**KIRKLEES METROPOLITAN COUNCIL
INVESTMENT & REGENERATION SERVICE**

**DELEGATED DECISION FOR APPLICATION FOR CERTIFICATE OF
LAWFUL DEVELOPMENT**

Reference no.: 2023/CL/91238/W

Site: 39, Hazel Grove, Cowlersley Lane, Linthwaite,
Huddersfield, HD7 5TQ

Proposed attic layout (1:100)

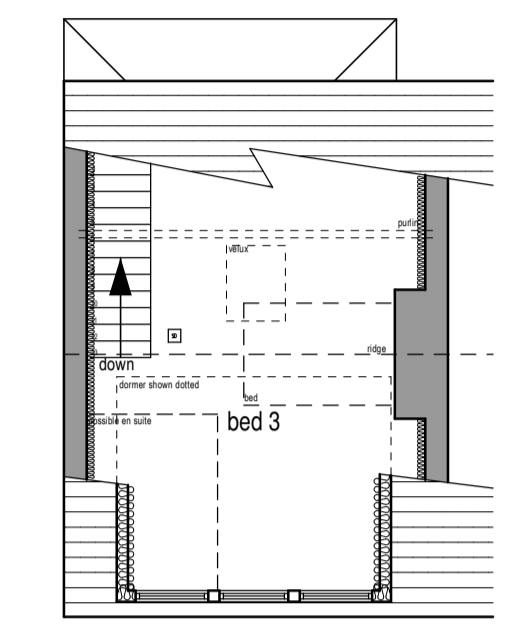
Permission is sought for a Certificate of Lawfulness for a proposed rear dormer. The rear dormer would measure 3.6m wide x 2.8m deep x 2.2m maximum height. The dormer would have a flat roof and would be faced in tiles to match the existing. The plans also indicate a roof light to be inserted into the front roof slope.

Comment: *The volume of the proposed dormer is 11 cubic metres. Therefore, the roof space would increase by less than 50 cubic metres.*

Proposed front elevation (1:100)

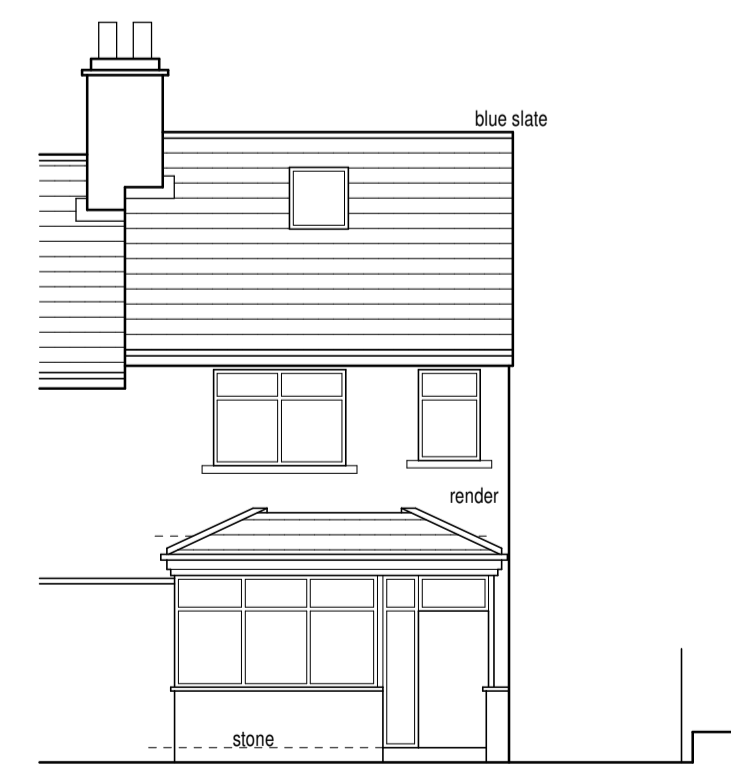
- (b) the alteration would protrude more than 0.15 metres beyond the plane of the slope of the original roof when measured from the perpendicular with the external surface of the original roof;

Comment: No

- (c) it would result in the highest part of the alteration being higher than the highest part of the original roof; or

Comment: No

Proposed rear elevation (1:100)

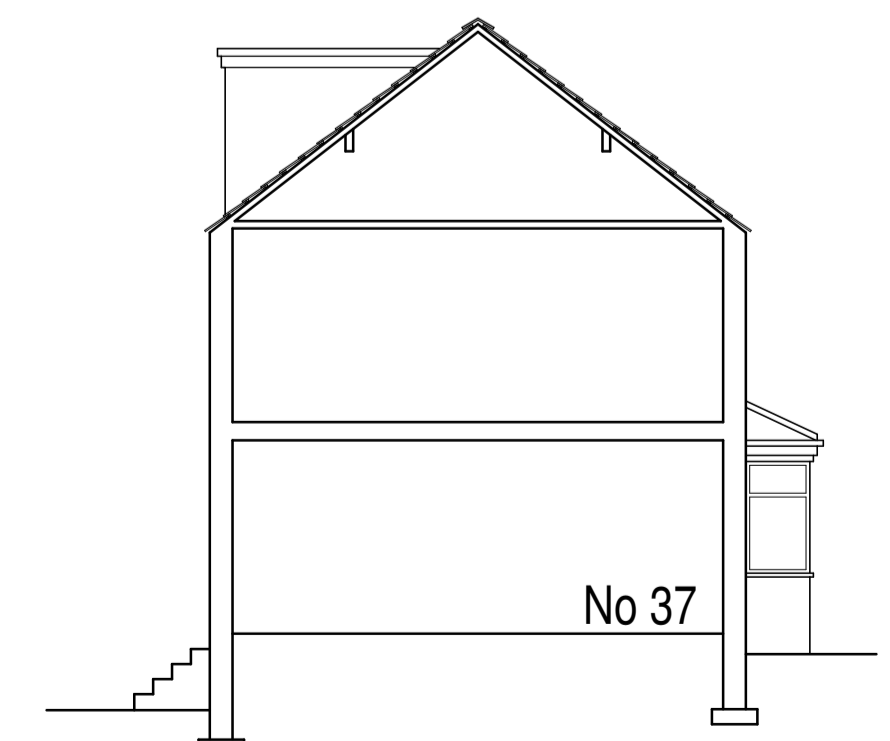
Comment: *The height of the highest part of the existing roof would not be exceeded by the proposals.*

Comment: *The proposed rear dormer extension would not extend beyond the plane of any existing roof slope forming the principal elevation of the dwellinghouse and fronting a highway.*

Comment: *The proposal would not consist of or include any of the above*

Comment: Approval is granted subject to the above conditions.
